Appendix A - Response to Government Agencies and Organisations Submissions

Trinity Grammar School - SSDA 10371
 119 Prospect Road, Summer Hill

Figure 3. Proposed new bike parking location (Source: PMDL, 2020)

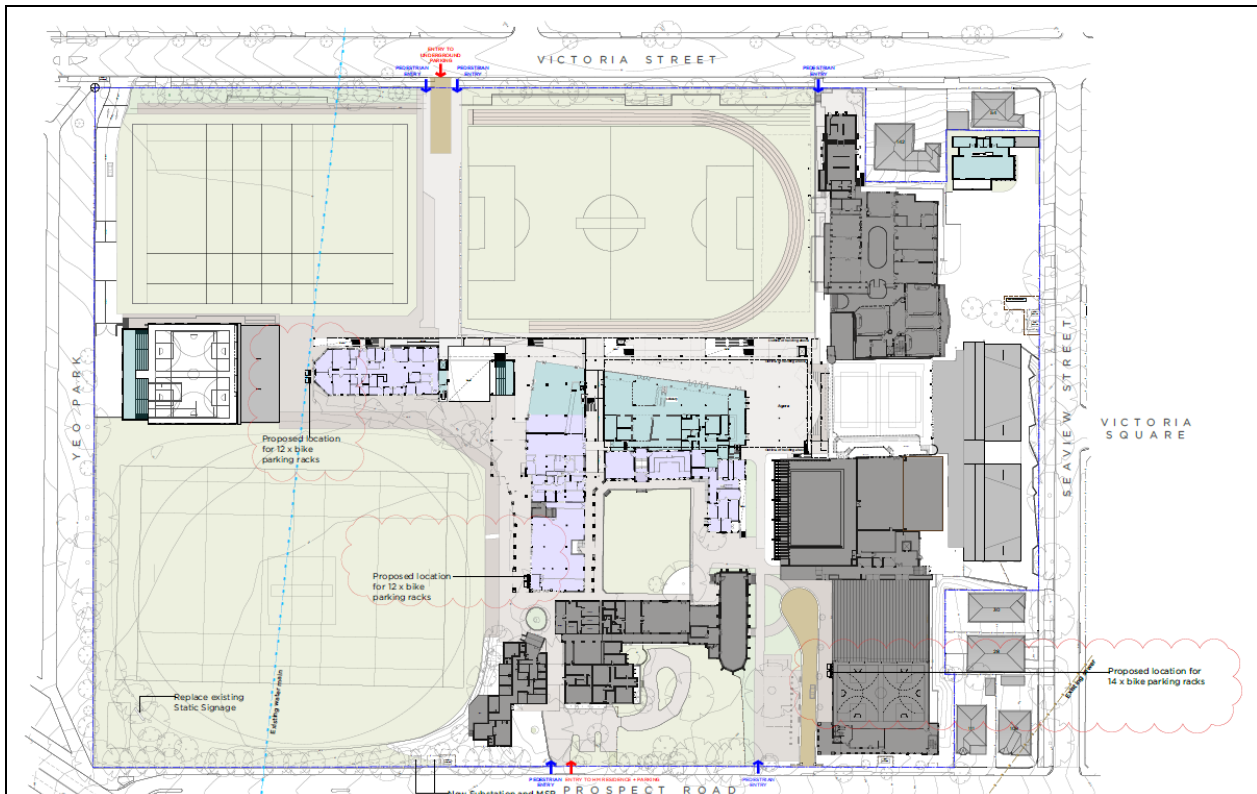
<ul style="list-style-type: none"> It is unclear whether bicycle parking spaces with end of trip facilities are provided on site. Adequate bicycle spaces with end-of-trip facilities should be proposed and identified in the architectural plans. 	<p>Under the original submission, the bicycle parking facility was identified on Drawing No. DA111, located within the basement car park. Access to shower and facilities for the end of trip facility are located in the existing aquatic facility.</p> <p>However, on further assessment, this location for the bike parking is not ideal given that bike riders will need to mix with the car park traffic to access the bike parking. The alternate is to enter the school at ground level, dismount, and walk the bike to the bike parking. These actions are likely to be a disincentive to bike riding.</p> <p>It is proposed to relocate the bike parking so that it is accessible from Prospect Road and closer to the end of trip facilities in the aquatic centre. Three potential locations are proposed, with final placement (or potential to consolidate these options into one or two locations) to be decided during detailed design.</p> <p>The proposed locations are shown in Figure 2 below:</p>

Figure 5. Gradings of significance of buildings (Source: Urbis, 2020)

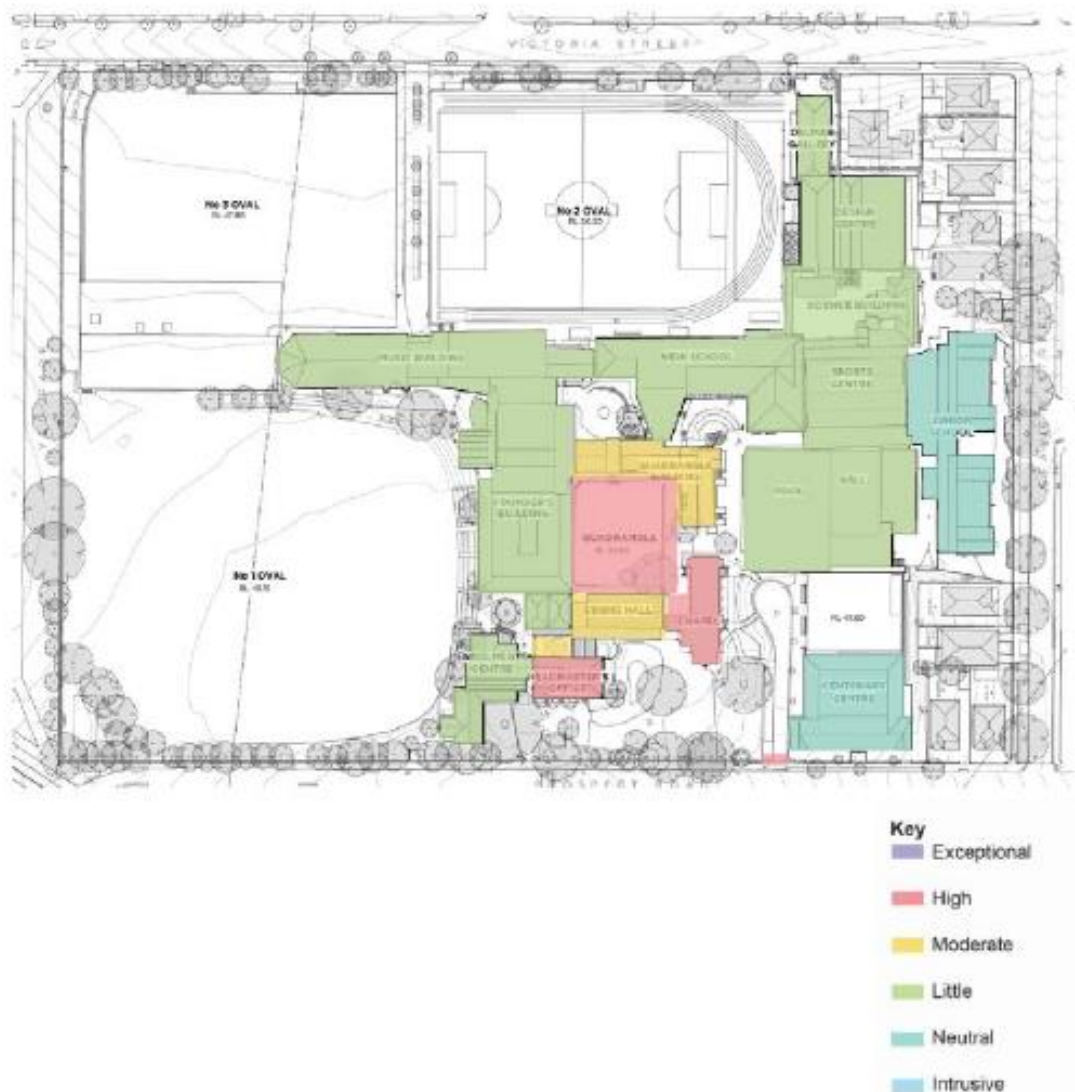
Table 1. Response to Government Agencies and Organisations Submissions	
Issues Raised	Proponent's Response
<p>and consequently does not meet the LEP aims for conserving the environmental heritage of the LGA.</p> <p>The supporting heritage and aboriginal heritage assessments have largely been compiled from secondary sources and neither document contains adequate documentary or physical research regarding the original landscape form. The reports do not demonstrate an understanding of the design and character of the sequence of significant buildings and associated landscaping and quadrangles progressively erected to create the school campus. This sequence of development including buildings and landscaping created for four different educational users including the private school, the NSW Department of Public Instruction (later Department of Education) and the Anglican Church is potentially of state significance. The architects of the various phases include the most significant designers of school buildings in the State.</p> <p>The conclusions of the HIS are not supported by Inner West Council's Heritage Specialists. Today interwar and post war works of architecture and landscape are also considered to be of cultural significance, and should have been assessed in relation to both the Collegiate Gothic and Tudor Revival tradition in School Architecture in Australia and in terms of the introduction of modern architectural trends in School Architecture (based on criticism of using historic motifs for the chapel in the mid 1950s).</p> <p>Inner West Council had established the heritage significance of three elements within the complex: the Chapel; the Headmaster's Residence and the gates in its Ashfield Heritage Study and the listings also mention the quadrangle. This inventory was undertaken in 1991/92 for Council by highly respected heritage consultants however the listing information has not been included in the SSD application (despite being provided by Council's heritage specialists).</p> <p>The Heritage Assessment does not contain sufficient documentary or physical evidence to support a change in the level of significance from</p>	<p>In summary amendments to the HIS include the following:</p> <ul style="list-style-type: none"> ▪ Minor additions to history to reflect updated research. ▪ Inclusion of known architects – this has been the focus of additional research, and has been assisted by Dr. Noni Boyd from Inner West Council. ▪ Further identification of the significant elements across the Site. ▪ Acknowledgements and limitation section – acknowledging the contribution of previous reporting and Dr Noni Boyd, as well as the limitations on research including poor record keeping post-war and the Covid-19 pandemic. <p>As part of the preparation of the amended HIS, further investigations were undertaken to determine the significance of the heritage items across the Site. It is concluded that the significant elements on the Site constitute the Headmasters House and grounds and the War Memorial Chapel. It is also considered that the following elements make a defining contribution to the significance of the Site overall, all with a high grading of significance, and should be retained:</p> <ul style="list-style-type: none"> ▪ Headmaster's Residence and Chapel Garden; ▪ Chapel Gates and Way; ▪ War Memorial Chapel Court; ▪ Dining Hall; ▪ Presentation of the North Quad. <p>Figure 6 below illustrates the gradings of significance for buildings across the Site.</p>

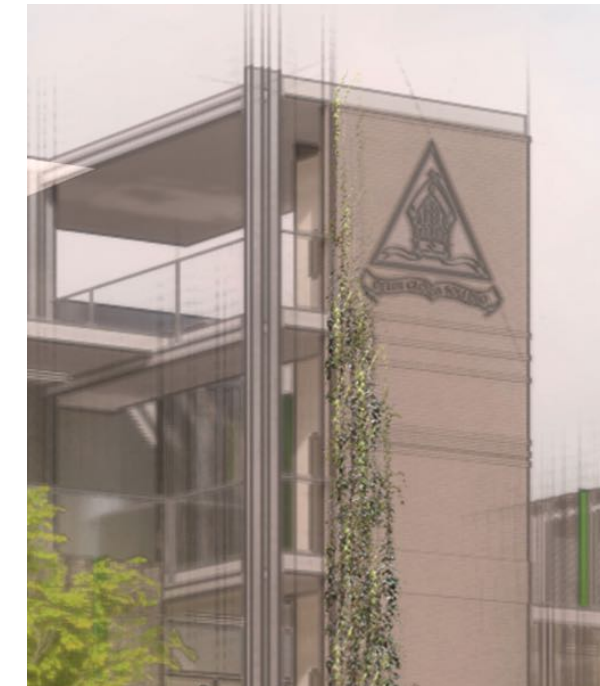
Table 1. Response to Government Agencies and Organisations Submissions	
Issues Raised	Proponent's Response
Signage	
<ul style="list-style-type: none"> The application seeks consent for a signage on the western façade of the new building. The details of the proposed signage including a clear elevation and dimensions must be submitted in this regard. 	<p>The proposed development seeks consents for the following signage:</p> <ul style="list-style-type: none"> Drawing No. DA501 Signage Location Plan; Drawing No. DA502 Signage Blade Wall; Drawing No. DA503 Lift Tower Signage; Drawing No. DA504 Scoreboard Signage; Drawing No. DA505 Prospect Road Signage; Drawing No. DA506 Centenary Centre Signage; Drawing No. DA507 Seaview Maintenance Signage. <p>The details of the proposed signage, including clear elevations and dimensions, accompany this submission as Appendix C.</p>
<ul style="list-style-type: none"> The EIS states that 'environmentally-sensitive lighting would be designed into the proposed signage'. Details of this lighting including lux levels is to be provided. 	<p>A Lighting and Lighting Control Strategy has been prepared by Acor and accompanies this submission as Appendix N.</p> <p>The lighting design will comply with the requirements of:</p> <ul style="list-style-type: none"> AS 4282 - Control of the obtrusive effects of outdoor lighting. <p>The lighting to be designed includes but is not limited to the following:</p> <ul style="list-style-type: none"> Obtrusive Lighting Control. <p>All luminaires will utilise LED technology lamps and the luminaire's reflector will be designed specifically for LED lamp sources.</p> <p>External lighting will be controlled via a combination of photo electric cells and time switches with a manual override control.</p> <p>Light fittings shall be provided with a finish to the school and architect's colour scheme requirements.</p> <p>All external lighting will be designed to have less than 1 lux light spill within 2 metres of the boundary, and will be lighting, which is aligned with any sensitive boundary areas, will be shielded to negate any discomfort glare issues with neighbouring properties.</p>

**01 ELEVATION**  
Maintenance Building Elevation East  
Scale 1:100

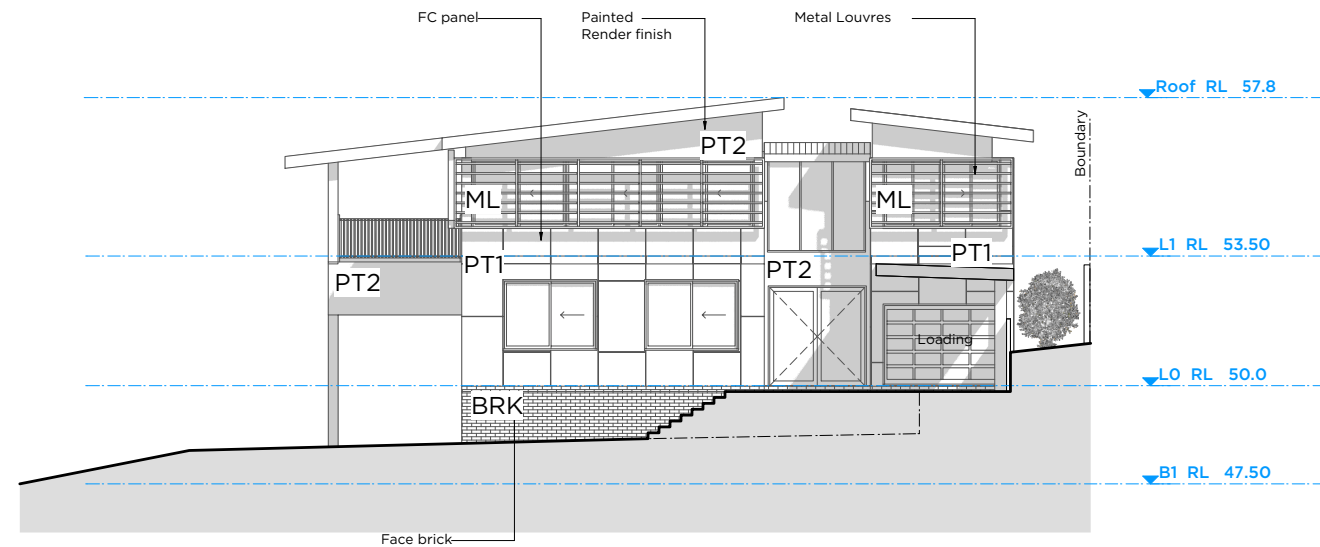
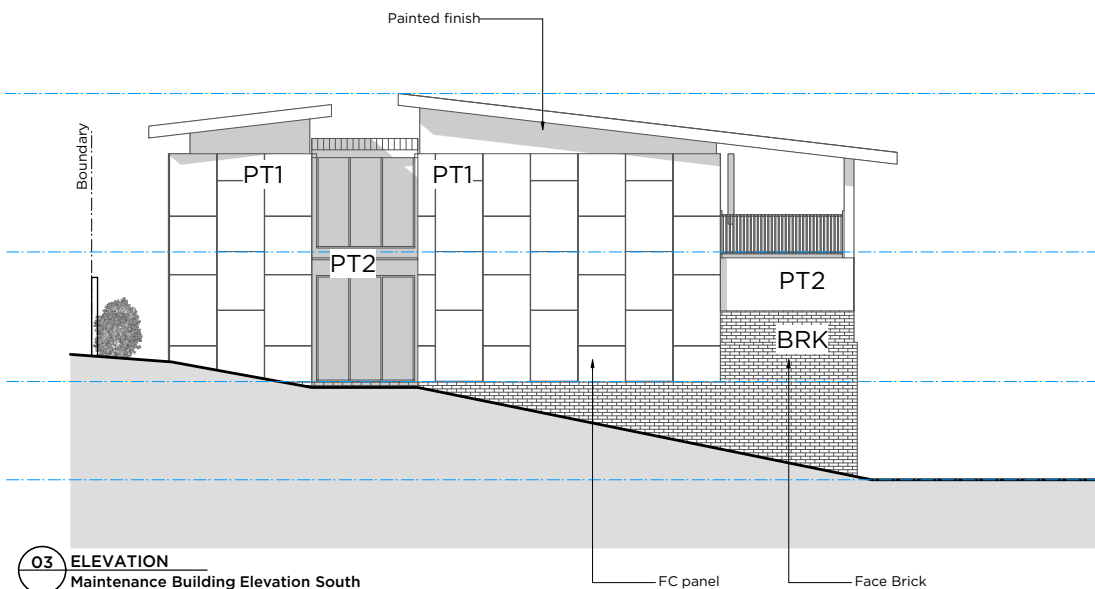
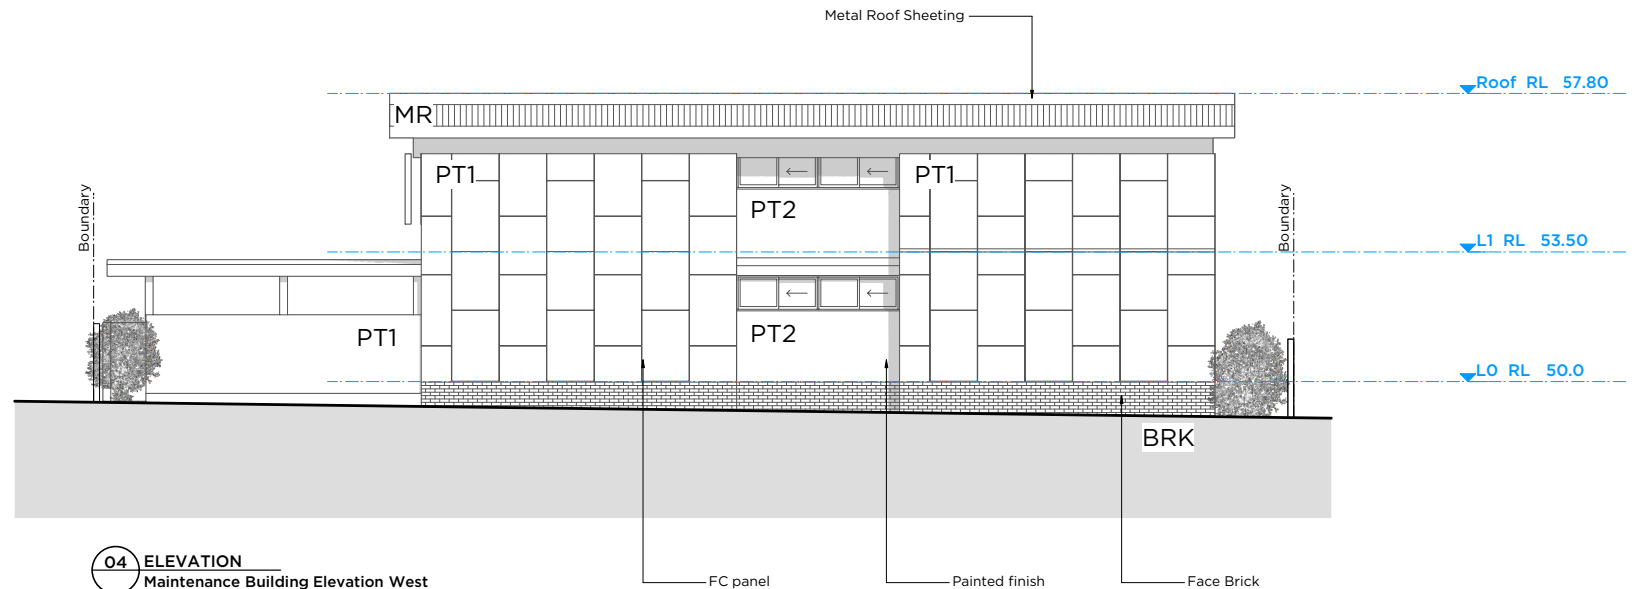
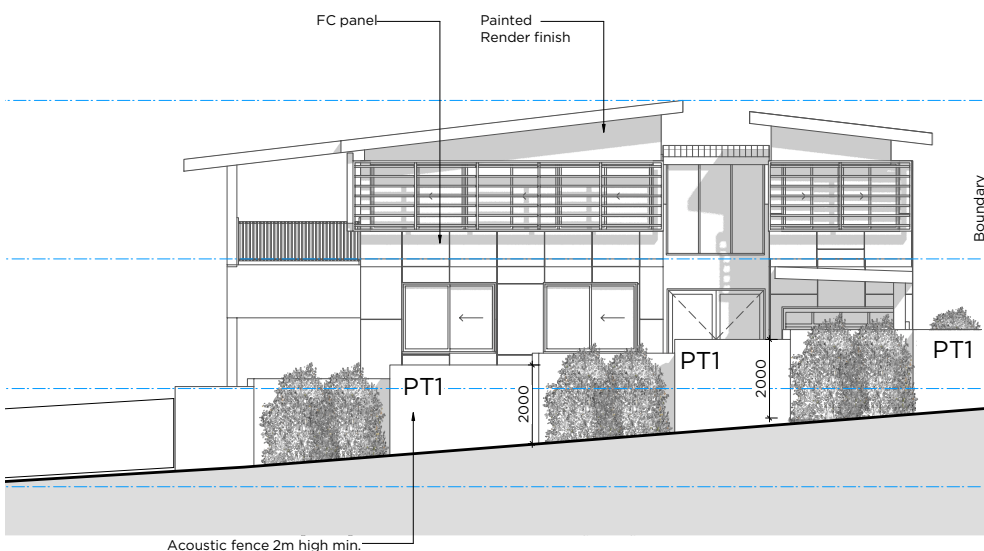
<ul style="list-style-type: none"> ▪ Details with regards to Seaview Street streetscape is to be provided including elevations and planting in front of the proposed new Maintenance Building to screen its bulk from the street. 	<p>Refer to Appendix F and Appendix G. As indicated on the landscape documentation prepared by Arcadia, <i>Acemena smithii 'minor'</i> is proposed to be planted along the Seaview frontage and will provide a level of screening to the new Maintenance Building when viewed from the public domain.</p> <p>A detailed elevation, Drawing No. DA308, has been prepared by PMDL and accompanies this application as Appendix C.</p>
<ul style="list-style-type: none"> ▪ The Arborist report should be updated to include a plan identifying trees to be removed and retained in two separate colours. 	<p>An updated Arborist Report has been prepared by Australis Tree Management (Appendix M).</p> <p>Under the original EIS, a total of 17 trees were identified to be removed to accommodate the proposed development. Further to the above, Australis Tree Management identifies ten (10) of the existing trees located on the Site are proposed for retention. Trees proposed for retention on site and adjoining properties will require implementation of tree protection measures to ensure their ongoing health and survival during construction.</p> <p>The Arborist Report has been updated to include a plan identifying trees to removed and retained in two separate colours.</p>
